Re:- **A/8/11 Avenals Farm, Angmering, barn conversion.**

Subject: A/8/11 Conversion of barn to residence for family members - Avenals Farm, Angmering

Conversion of barn/store into private residence for family members (re-submission of A/124/10/)
Avenals Farm Water Lane Angmering BN14 7RA

A/8/11

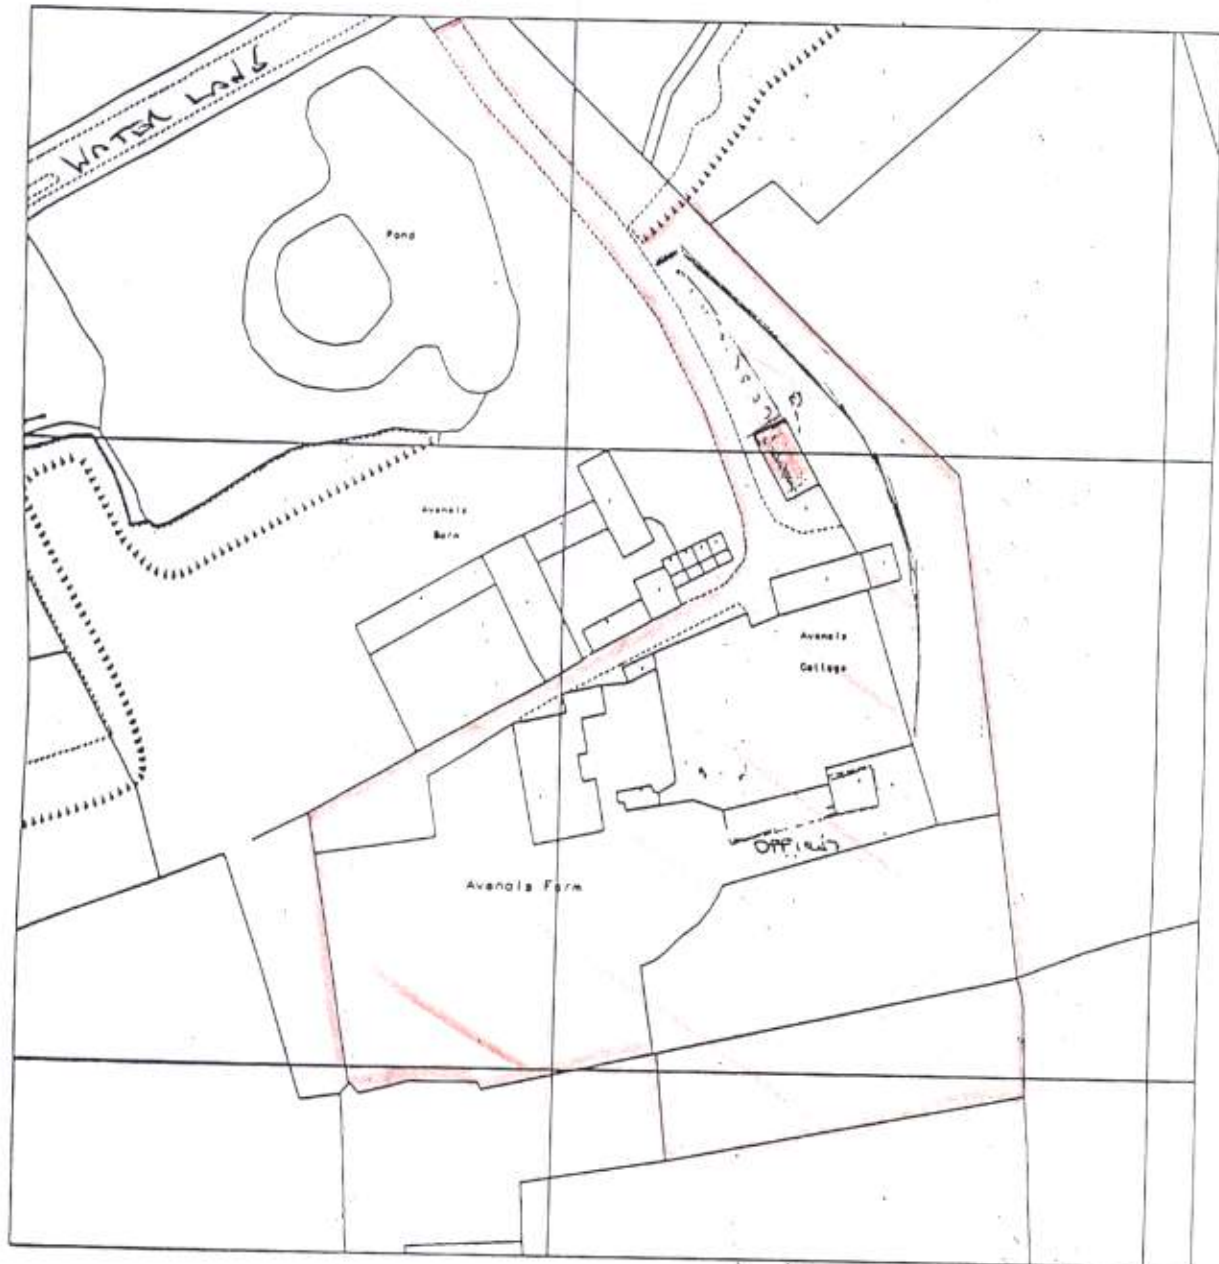
I require 1 electronic or 3 paper copies of a revised location plan at a scale of 1:1250 (the plan provided is not to scale) in accordance with the guidance notes available on our website detailed below (click on National List). X

Regarding the 1:500 plan this is to scale and we have now marked a road name on the plan although no name was shown on the original 1:1250 plan we obtained from Ordnance Survey. This is also now marked accordingly.

ARUN DISTRICT COUNCIL		
NO.	A 8	11
SUBSTITUTION		
Received	4-4-11

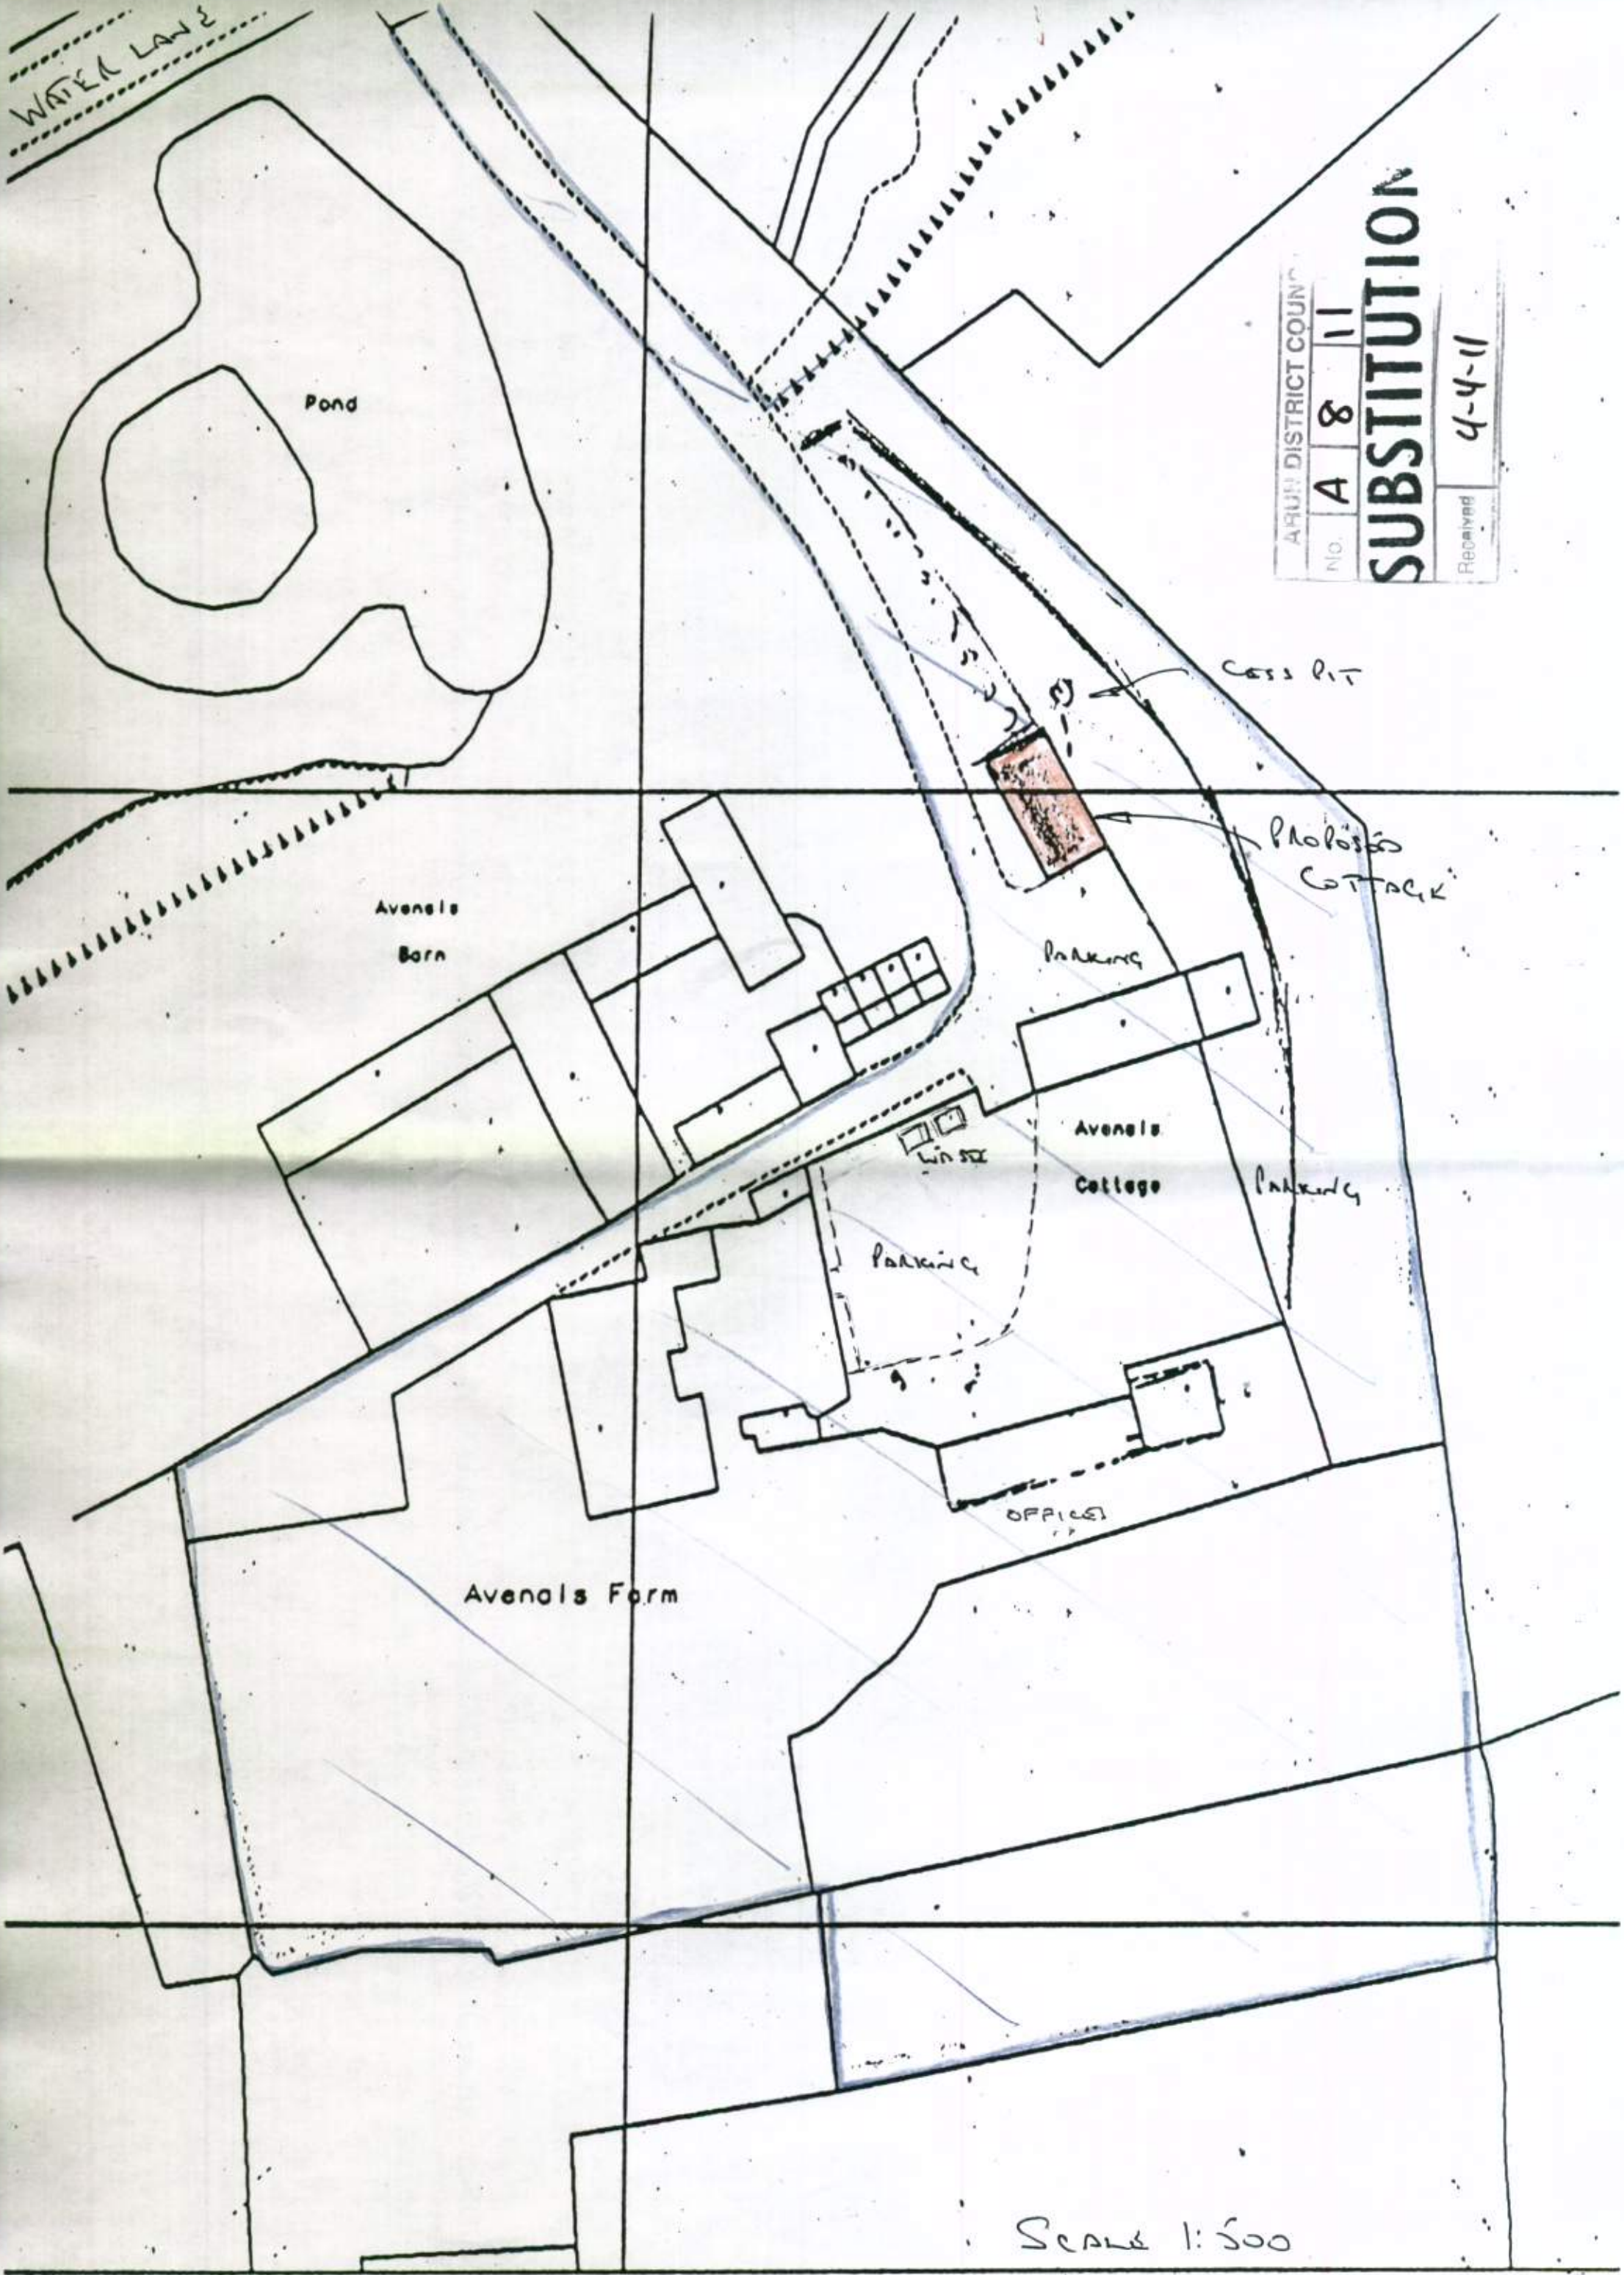
The site plan and block plan both have red edging around the whole of Avenals Farm. This should be blue with only the application building edged red.

1. Revised site plan and block plans attached with just the proposed altered building coloured red, the balance of the site edged in blue.
Only the proposed building is now coloured for as suggested in your e-mail dated 6th January 2011 the use of a separate garden for this property was unnecessary and therefore the garden of the main dwelling will be used.
